Historic England

**HBMCE Comments on proposed changes by third parties to the
DCO (as submitted at Deadline 4)**

**Highways England for an Order granting Development Consent for
the A303 Amesbury to Berwick Down**

Deadline 4A Submission 5 July 2019

EXISTING A303 STOPPED UP, NO CHANGE TO BYWAY AMES 12

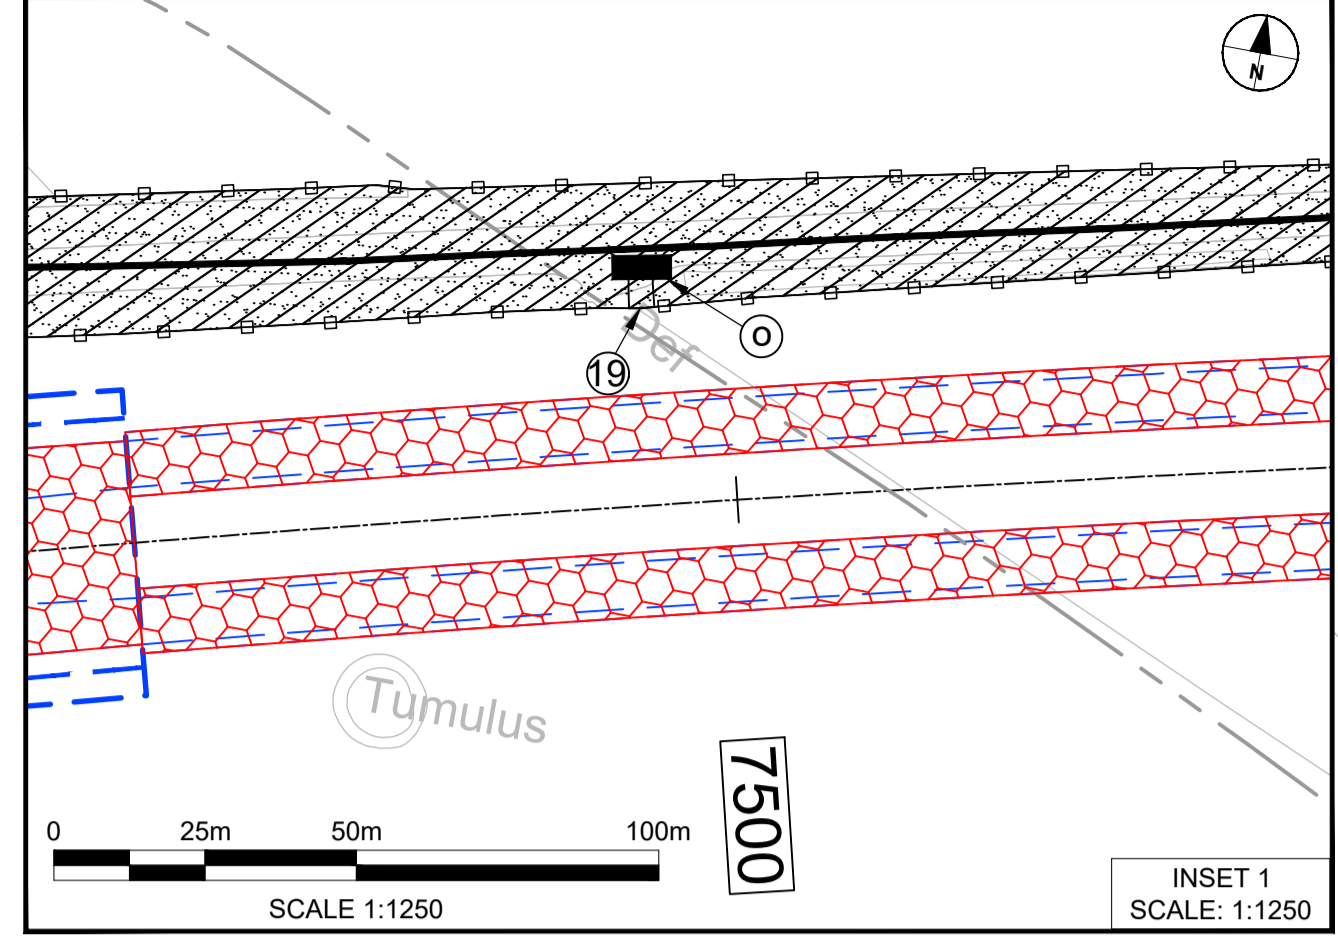
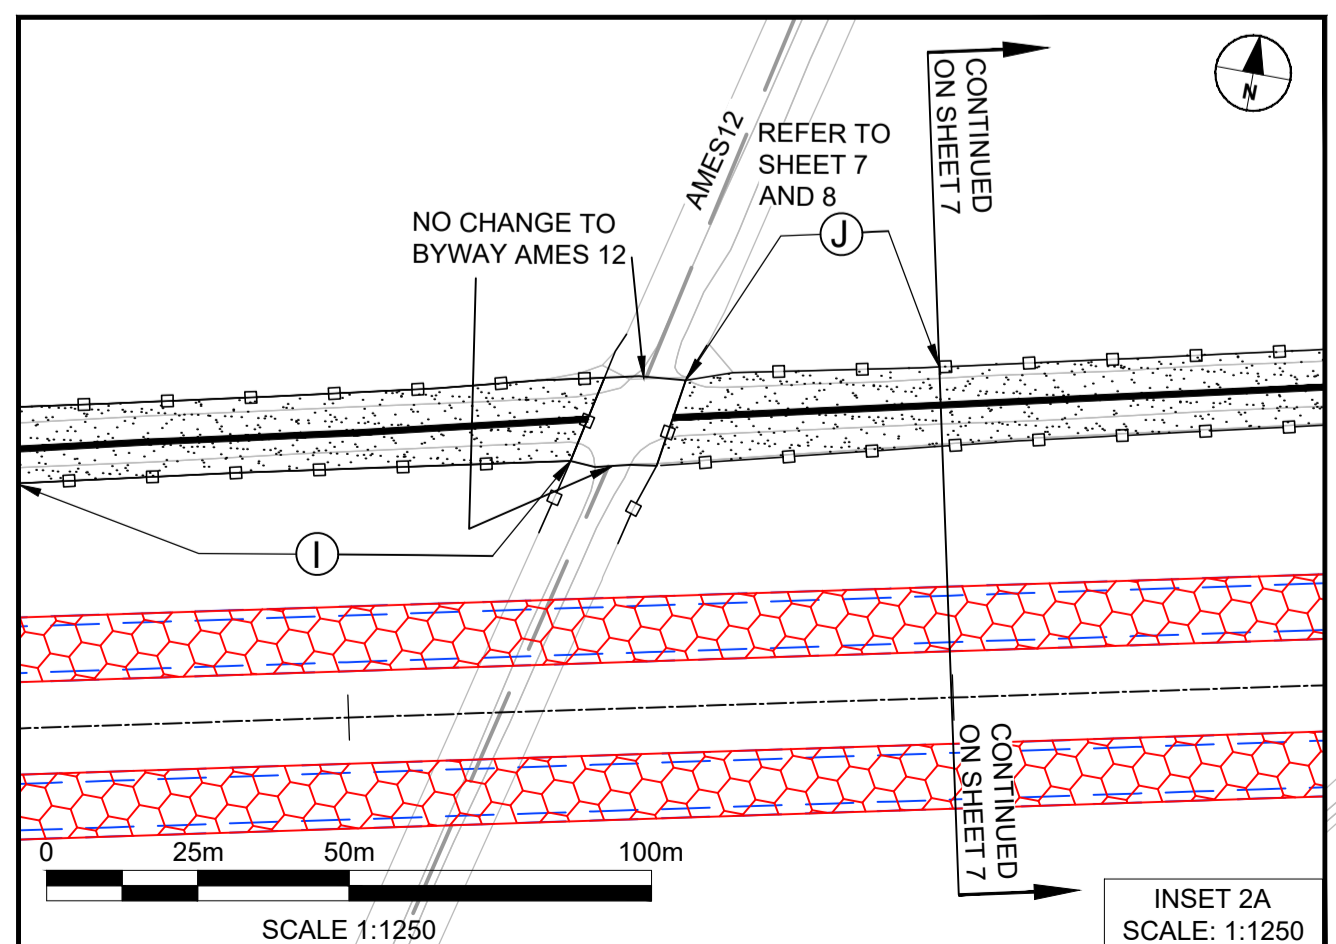
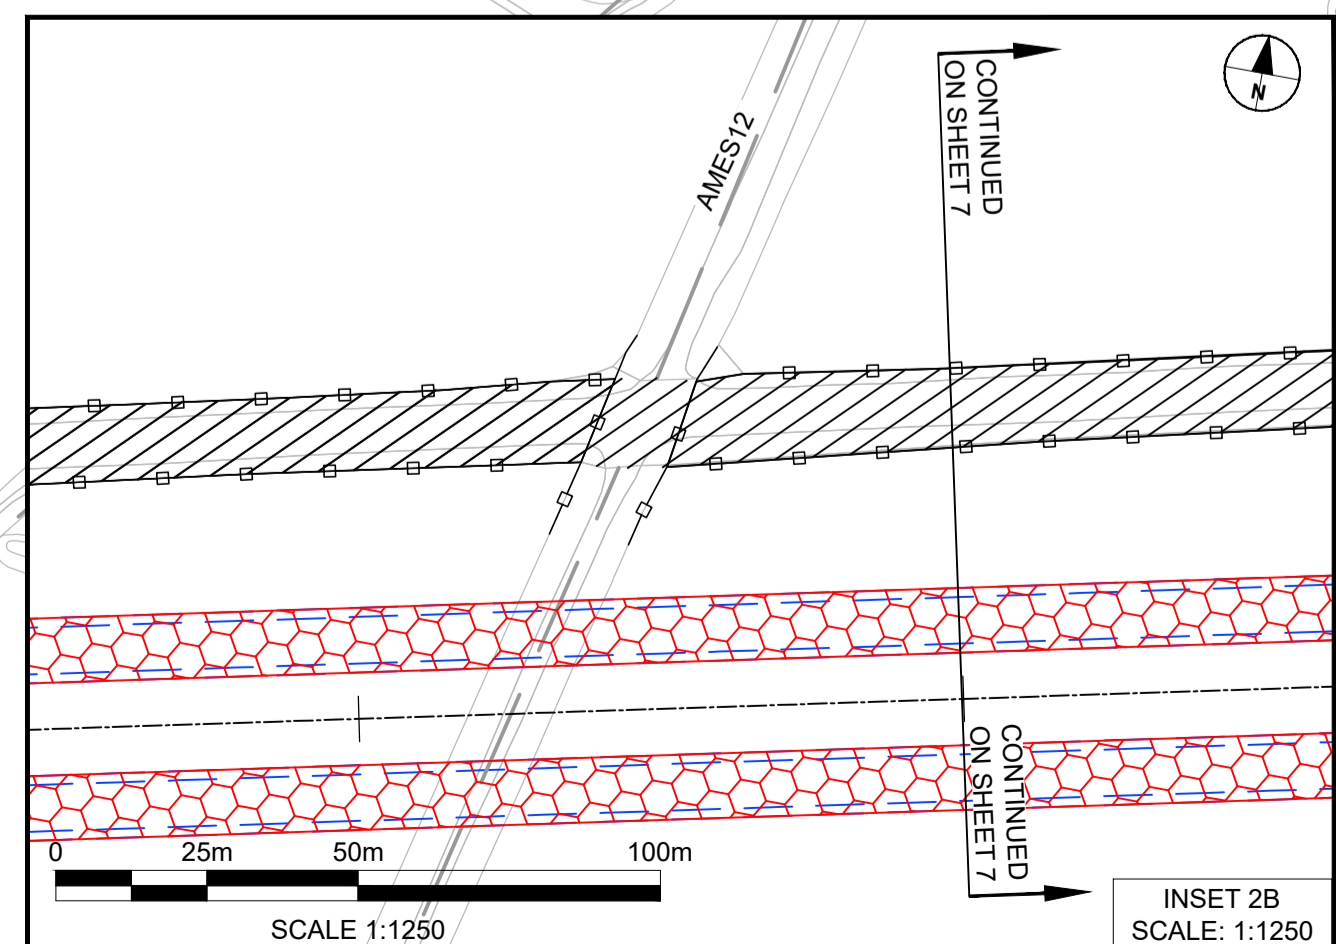
14. What does not appear to be clear from the above, and does not appear to have been shown on the Rights of Way and Access plans or other plans, nor is it shown where and how this turning facility will be provided. Nor does there appear to be any mention of the turning facility in any of the works noted in Schedule 1 to the DCO itself. It would be helpful to establish the proposed location and provision of this turning facility to be able to understand the implications that this would have for the historic environment.

15. As a consequence of these proposals, it is possible that the management of both byways 11 and 12 will be affected, in particular if there was the creation of a turning facility, cul de sac and gating requirements should byway 11 be retained as a BOAT with or without some form of a link facilitating motorised access between byway 11 and 12.
